Rosefield Solar Farm (EN010158)

**Buckinghamshire Council's Comments on the Applicant's
Updated Deadline 4 Documents and Comments on
Schedule of Changes to Draft DCO**

Buckinghamshire Council

July 2026

Project:	
Title:	
Location:	
Additional detail:	
File name:	Rosefield_A41-Station Rd Junction.lsg3x
Author:	
Company:	
Address:

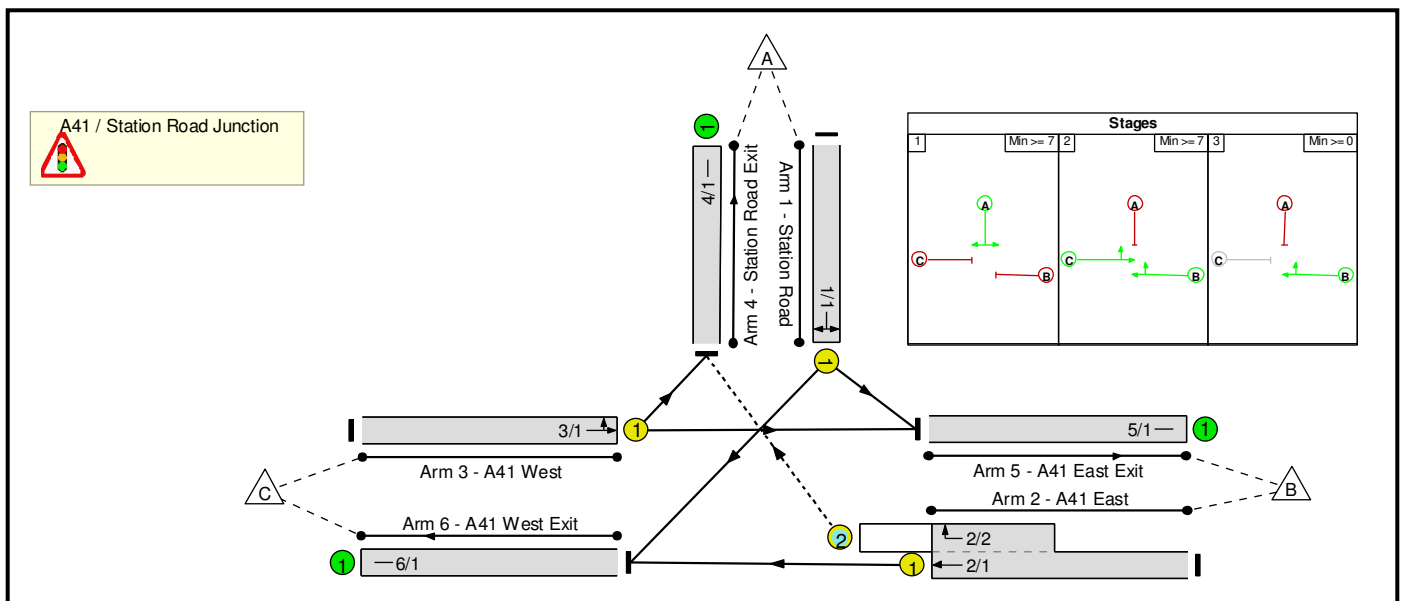
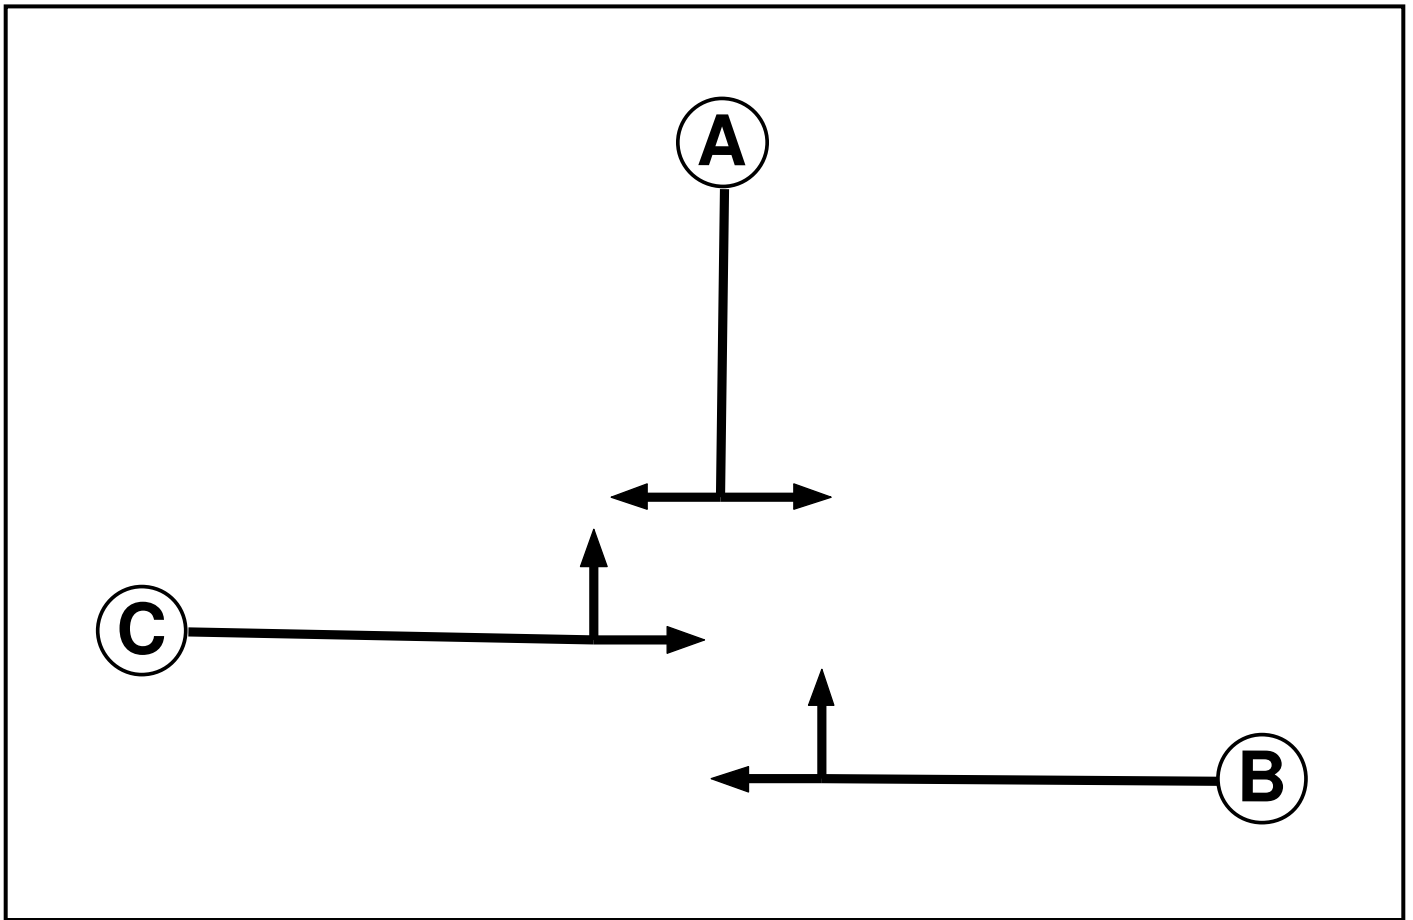
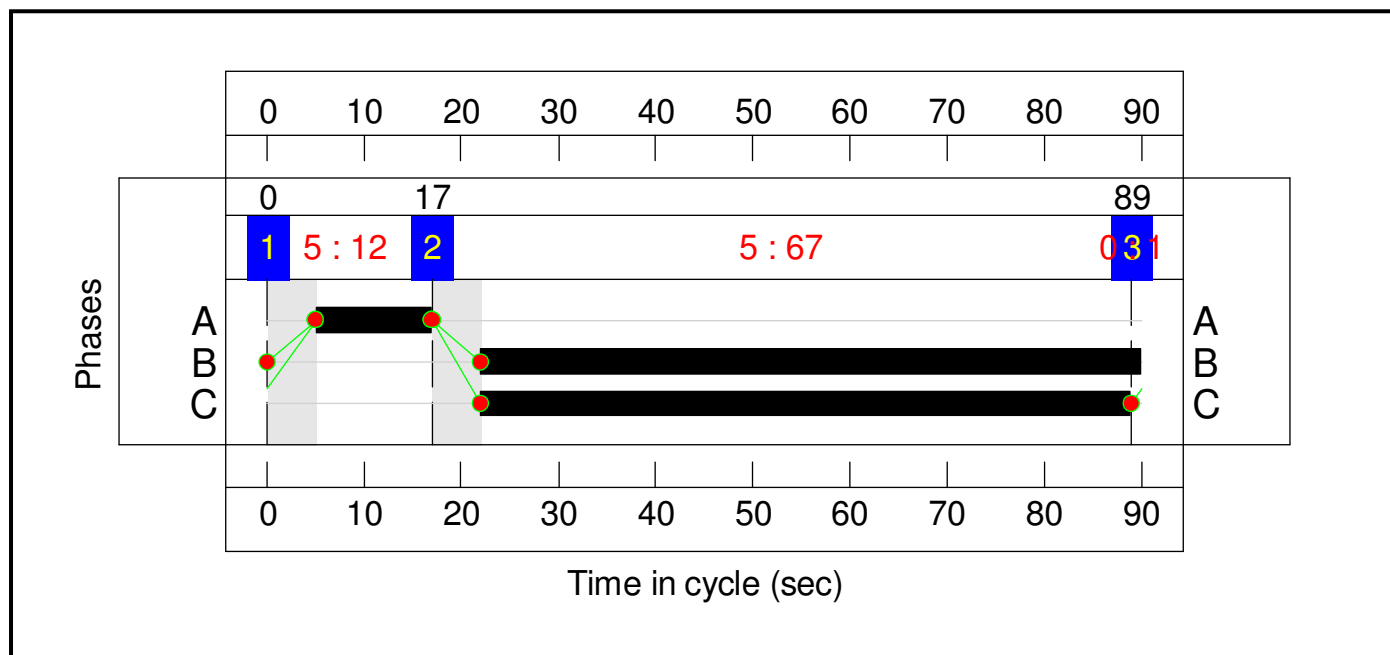
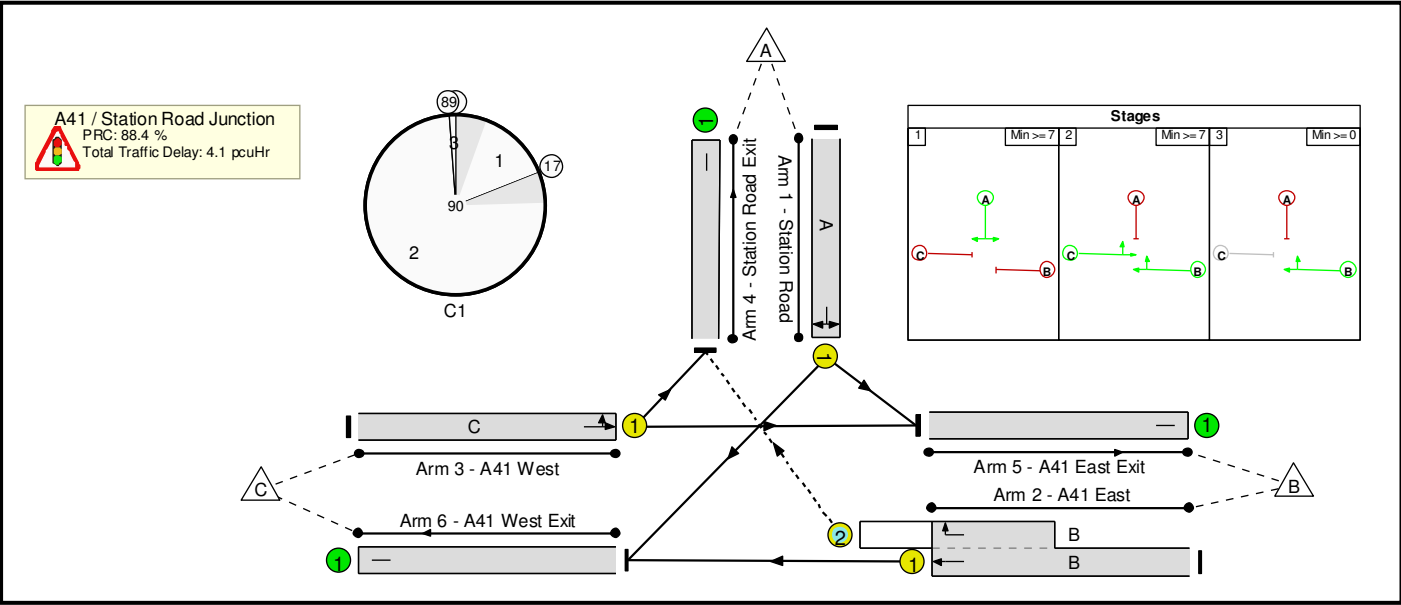
REP4-047	Rosefield Energyfarm Limited	6.4.2 Environmental Statement Volume 4 Appendix 15.1 - Transport Assessment (Tracked) (Revision 2)	The changes are accepted, and the modelling addition included has demonstrated that the A41/Station Road junction has sufficient capacity to accommodate the construction traffic.
REP4-061	Rosefield Energyfarm Limited	6.4.3 Environmental Statement Volume 4 Appendix 9.1 - Archaeological Desk-Based Assessment and Setting Assessment (Tracked) (Revision 3)	In relation to the content of [REP4-060] the Council has the following comments in relation to the individual heritage assets where there is change to the Applicant's assessment:
